MORGAN AND MORECAMBE OFFSHORE WIND FARMS: TRANSMISSION ASSETS

Annex 2.2 to Applicants' Response to Deadline 4 submissions from Statutory Consultees and other organisation: Fylde Borough Council (REP4-134)

Deadline: Deadline 5
Application Reference: EN020028

Document Reference: S_D5_2.2

**Figure 1.16: Hedgerows – Section 5**

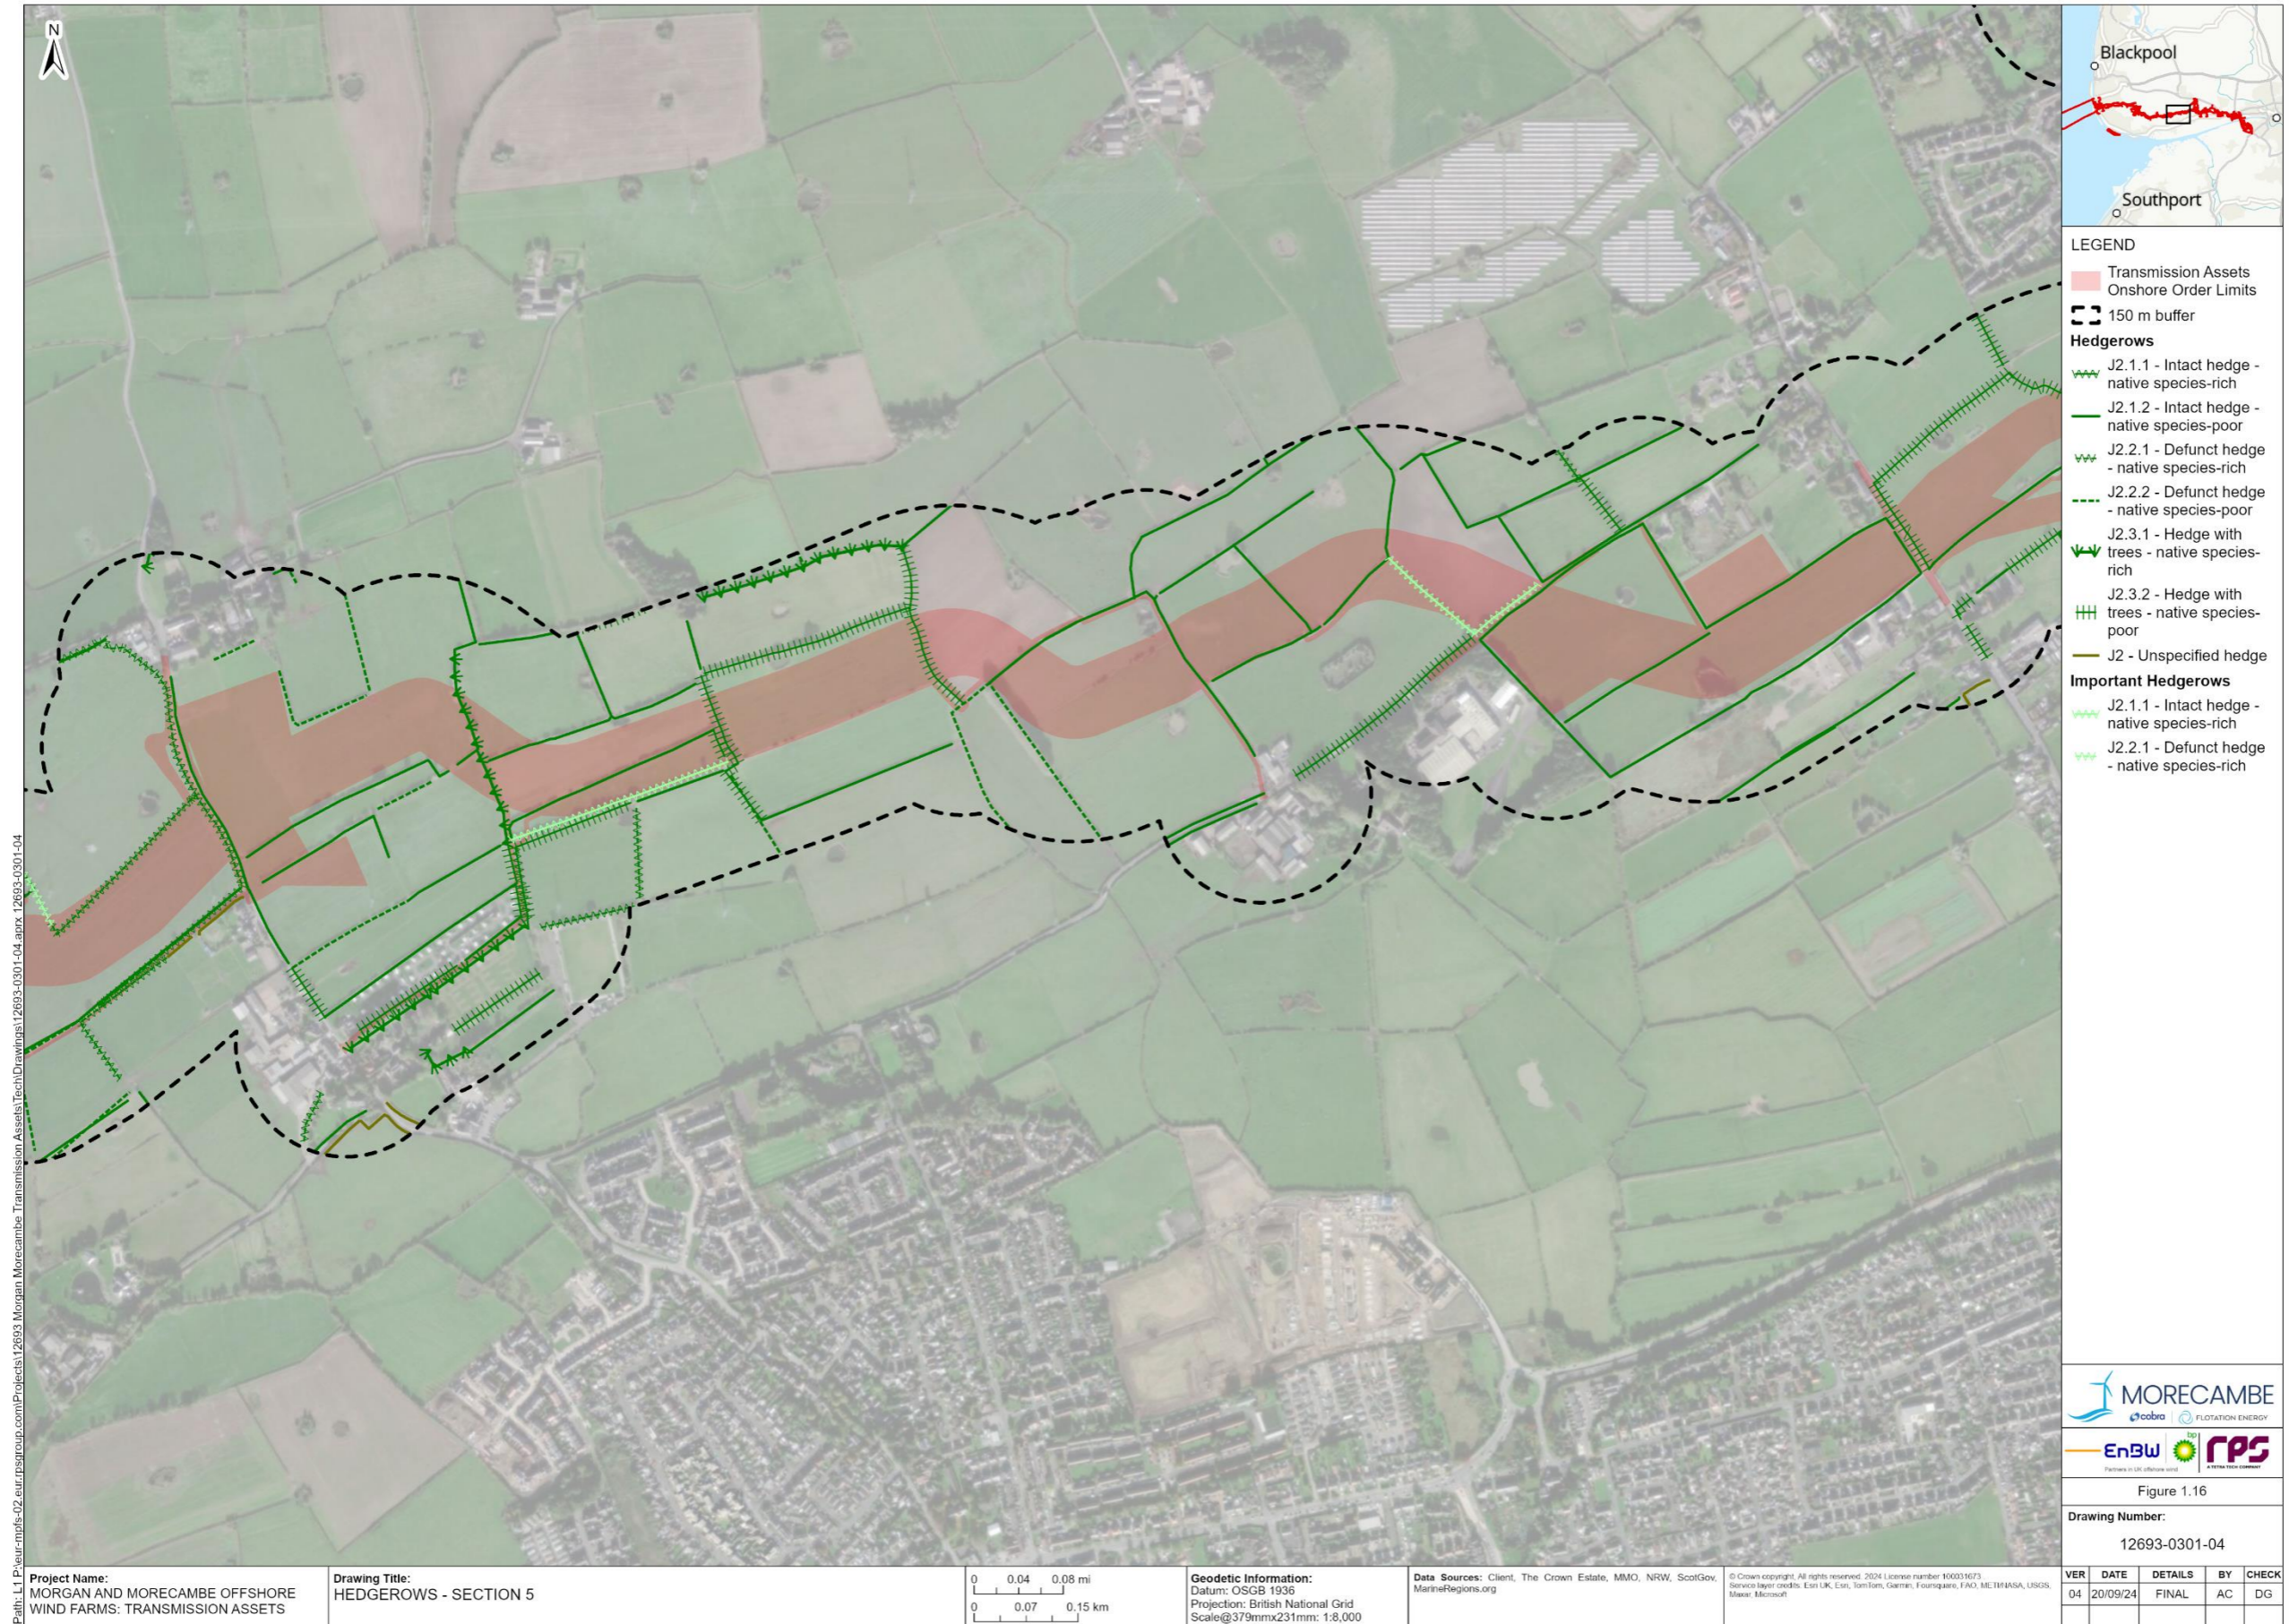
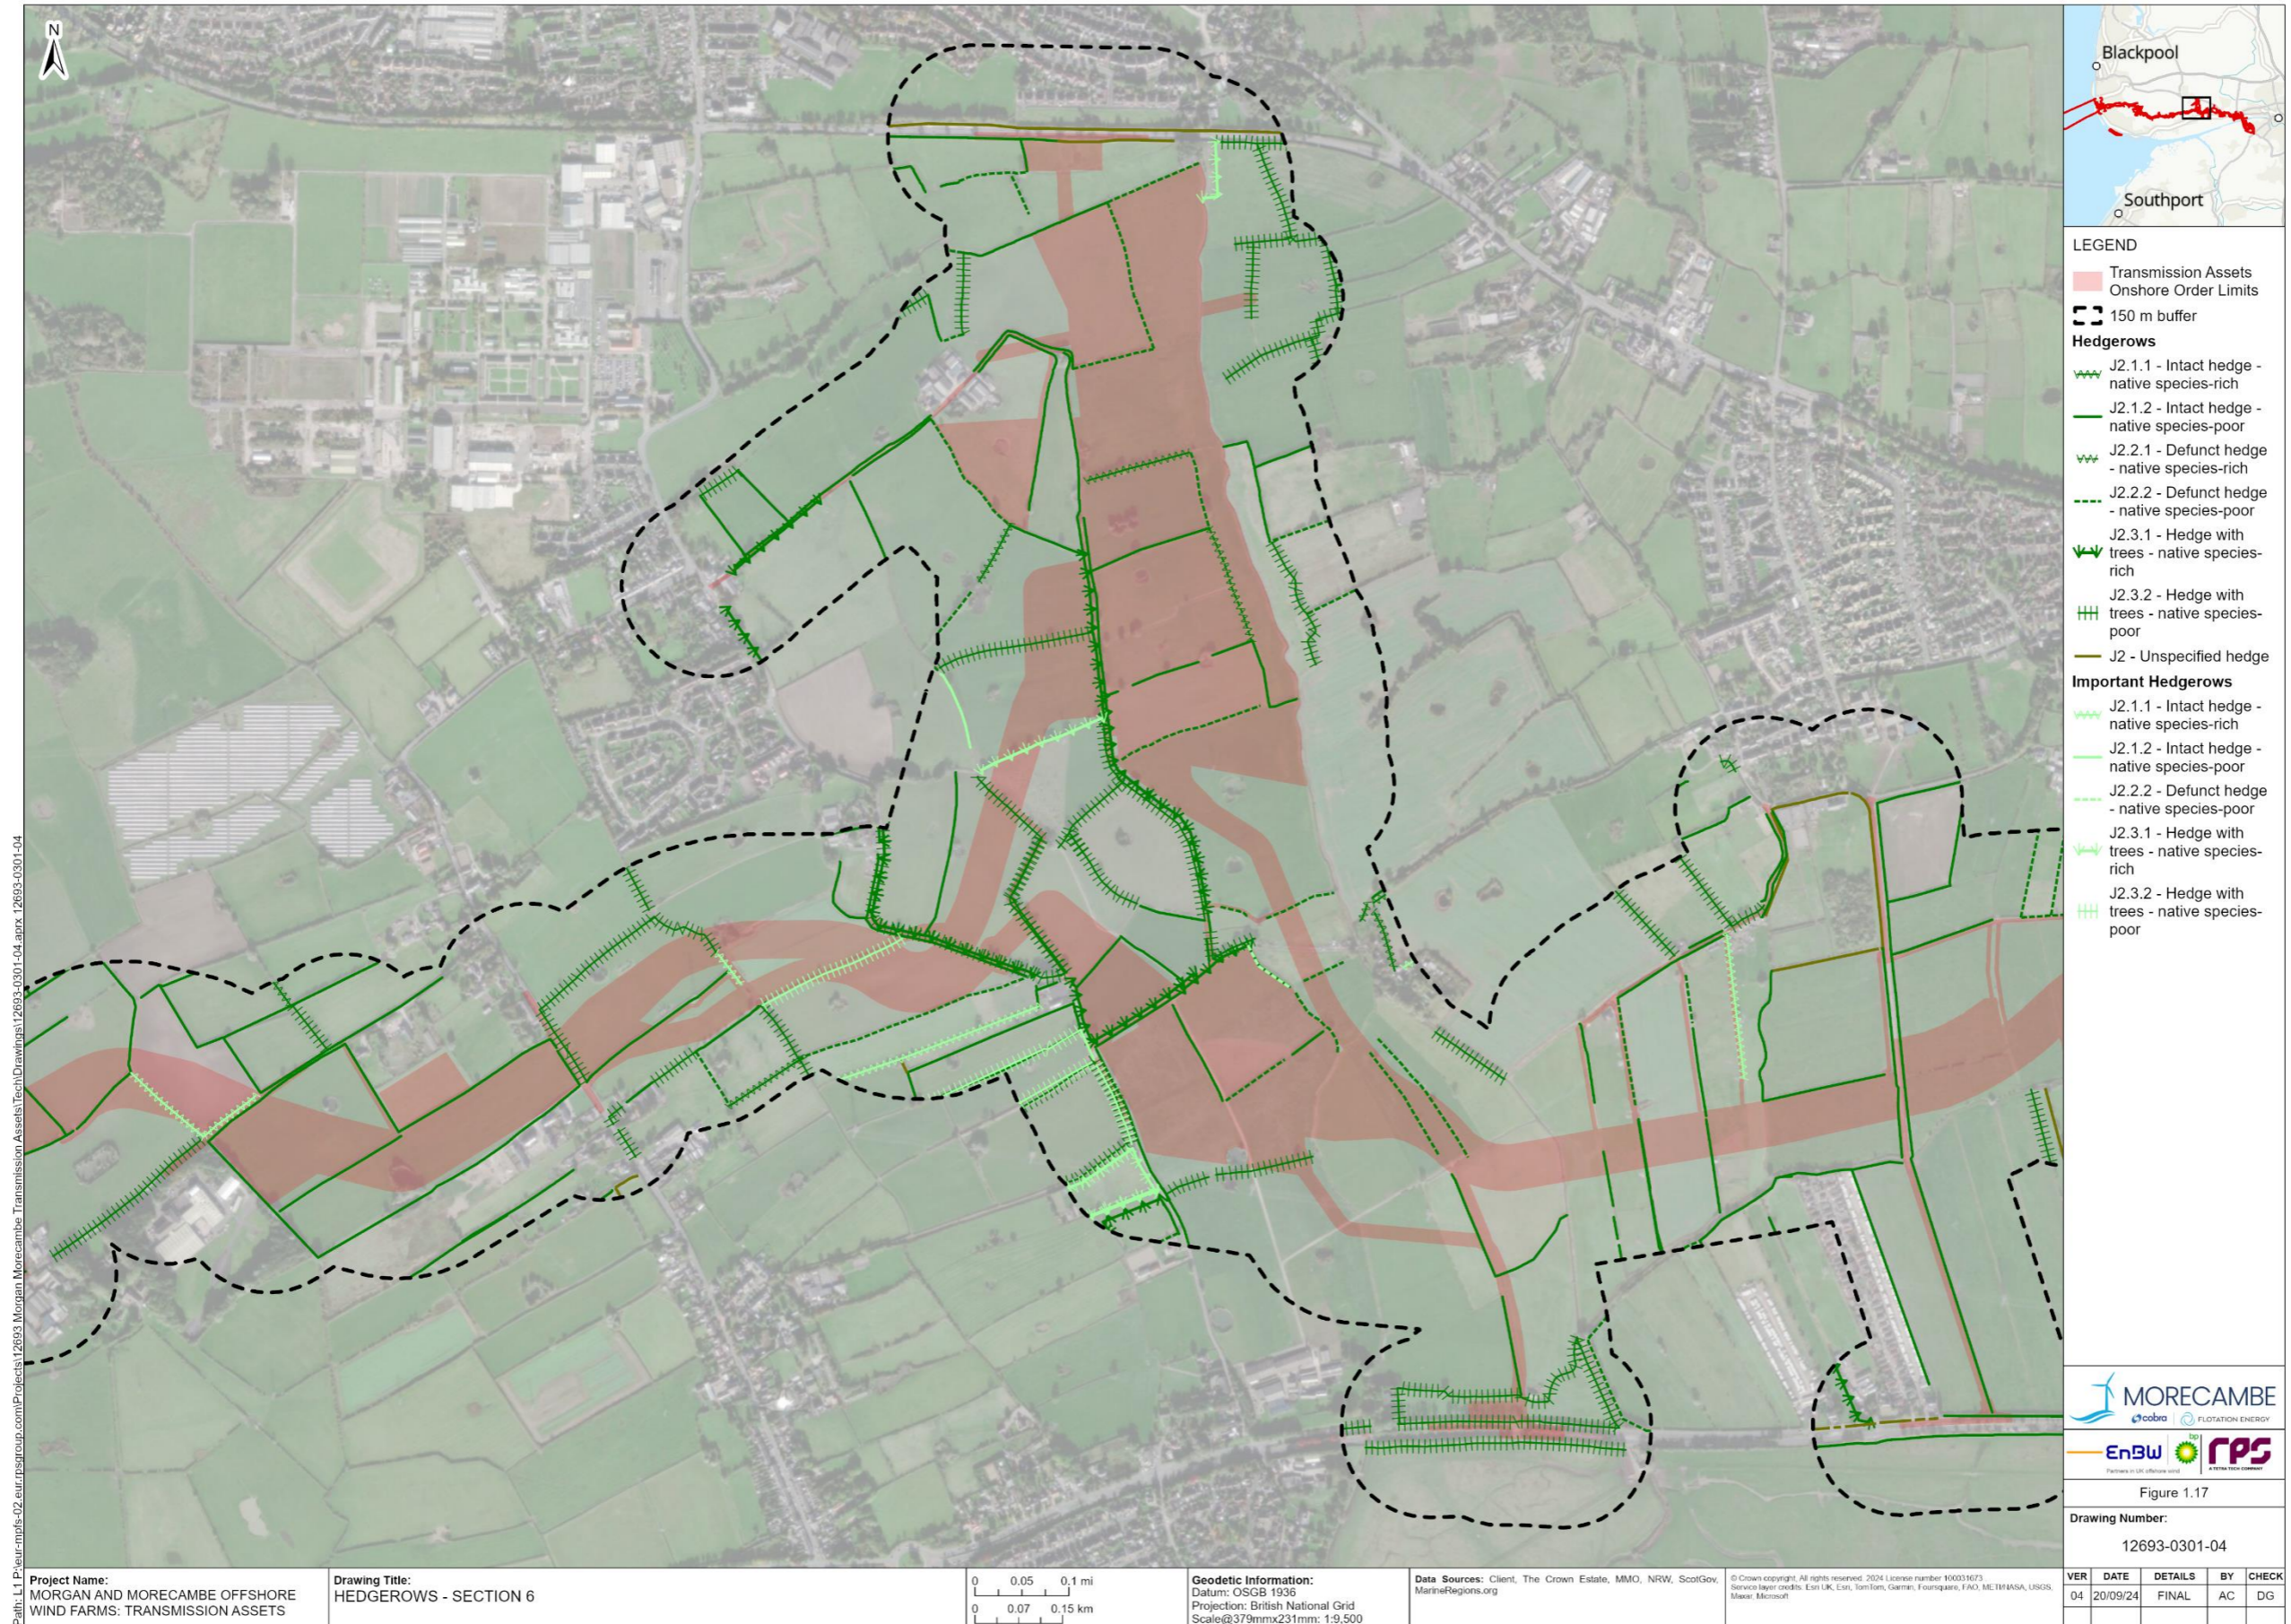
<p>REP4-134</p> <p>134.14</p>	<p>5.2 Scope of Hedge Removal</p> <p>5.2.2 The amount of hedgerow to be removed, as identified in Schedules 11A and 11B of the dDCO [REP3-009] is very large, at approximately 25km total. This is due to the large extent of the cable routing and Order limits significantly resulting in a greater and extended impact.</p> <p>5.2.3 Importantly, Section (4) of Article 35 of the dDCO allows for the removal of any hedgerow within the Order limits, in addition to those identified in Schedules 11A and 11B. FBC considers this to be unwarranted, inappropriate and not in accordance with Good Practice Point 6 of 'Advice Note Fifteen: drafting Development Consent Orders'</p>	<p>The Applicants have reviewed the wording of Article 35 against the Mona Offshore Wind Farm Order 2025 and consider that it is appropriate to update the drafting such that, unless otherwise agreed, Morgan can only remove important hedgerows that are identified in Schedule 11A and Morecambe can only remove important hedgerows that are identified in Schedule 11B. This is qualified by the inclusion of 'unless otherwise agreed', in light of the fact the Applicants have not been provided with full land access across the entire onshore Order limits and therefore it is possible that additional hedgerows may be identified when access to those areas of land is taken post consent. In the case of refusal,</p>

Reference	IP submission	Applicants' response
	<p>which requires all hedgerows affected by the proposed development to be identified within the Schedules.</p> <p>5.2.4 FBC requires that the applicants prepare a Schedule and plan in accordance with Good Practice Point 6 and that Article 36 of the DCO be updated to engage appropriately with these matters.</p>	<p>Morgan/Morecambe would be required to obtain a separate consent for removal of that important hedgerow.</p>
<p>REP4-134 134.15</p>	<p>5.3 Standards for Works to All Trees and Hedges</p> <p>5.3.2 Article 35 of the dDCO [REP3-009] allows for works to trees and hedges, including felling and removal, without any appropriate control.</p> <p>5.3.3 Neither the dDCO, nor the Commitments Register [REP3-013] make reference to any controls or standards in terms of how works under Article 35 would be carried out. A specification of works is therefore required.</p> <p>5.3.4 Section 5.11.27 of EN-1 includes a requirement for existing trees to be retained wherever possible and compensation provided where loss is unavoidable. It is entirely reasonable to extend this principle to require that works to retained trees to be carried out in such a way that harm to the long-term health of those trees is minimised.</p> <p>5.3.5 FBC therefore considers it appropriate to include control either within the DCO or Commitment Register, such as that works should be carried out in accordance with BS3998:2010 and BS5837:2012, and that tree health checks should be conducted by a suitably qualified Arboricultural Clerk of Works to satisfy the monitoring and supervision requirements within BS5837:2012.</p> <p>5.3.6 FBC requires like for like replacement for hedge loss, to achieve this recording of the hedge removal, tree/shrub species and soil types needs to be fully recorded. This is consistent with EN-1, FBC Local Plan Policies ENV1 and ENV3, and 'Advice Note Fifteen: drafting Development Consent Orders'.</p>	<p>The Applicants have prepared an outline Arboricultural Method Statement (S_D5_10) which is secured through Requirement 8 of Schedules 2A and 2B to in the draft DCO (C1/F07). Measures include but are not limited to:</p> <ul style="list-style-type: none"> Any further surveys required would be undertaken in accordance with BS5837:2012 All works to trees shall be carried out in accordance with BS3998:2010 and latest arboricultural best practice. All tree work shall be carried out by suitably qualified, competent and insured arboricultural contractors in accordance with Arboricultural Association Standard Conditions of Contract and Specifications for Tree Works (2008) Edition Measures to ensure tree health is considered and maintained throughout construction (such as construction exclusion zones and tree protection fencing) <p>The Applicants have also updated Section 1.6.3 of the Outline Ecological Management Plan at Deadline 5 (REF) to provide further clarity of the measures that would be in place to ensure the removal of and works to hedgerows are minimised. The measures include but are not limited to:</p> <ul style="list-style-type: none"> All hedgerows and trees retained within, or on the boundary of, construction work areas will be appropriately protected from damage during the construction works. A theoretical root protection area (RPA) is to be calculated, to ensure hedgerows and associated trees are not harmed by development activities

Reference	IP submission	Applicants' response
		<ul style="list-style-type: none"> Ensuring that all hedgerow removal works will comply with 'BS 5937:2012 Trees in relation to design, demolition and construction – Recommendations' Where hedgerow removal is proposed, works will be undertaken under ecological supervision. <p>In addition, paragraph 1.4.2.3 of the Outline Landscape Management Plan (REF) states that one of the main objectives of the landscape proposals is to reinstate land and plant replacement trees, hedgerows and other vegetation where practicable.</p>
REP4-134 134.16	<p>6 Ecology (Excluding dunes)</p> <p>6.1.2 FBC has provided separate comments relating to the sand dunes area within this written response.</p> <p>6.1.3 FBC notes the Action Points arising from ISH2 and ISH3 as they relate to ecology and will review the new and updated information as it becomes available. FBC expects to provide further written submissions, particularly in response to the range of Outline Management Plans relevant to ecological matters.</p> <p>6.1.4 FBC will also continue to engage with the applicants on matters relating to ecology. FBC can confirm that a series of meetings have been schedule ahead of Deadline 5 which should allow a substantively complete Statement of Common Ground [SoCG] to be submitted at Deadline 5, insofar as it relates to ecology.</p> <p>6.1.5 However, FBC also notes ongoing engagement between the applicants and key ecological consultees, notably Natural England and the Environment Agency. FBC notes with some concern the range of outstanding issues, including in relation to matters which have been a point of either disagreement or slow progress since at least 2023.</p> <p>6.1.6 The remainder of this section provides a summary of oral submission made by FBC at ISH2 and ISH3 as they relate to ecology.</p>	<p>The Applicants can confirm an SoCG meeting was held with Fylde on 5th September.</p> <p>The Applicants can confirm that there is ongoing engagement with EA and NE to discuss these matters. We consider this level of engagement to be typical of a project of this type and size and not anything of concern. Progress has been made on these issues and we do not consider this to be slow.</p>
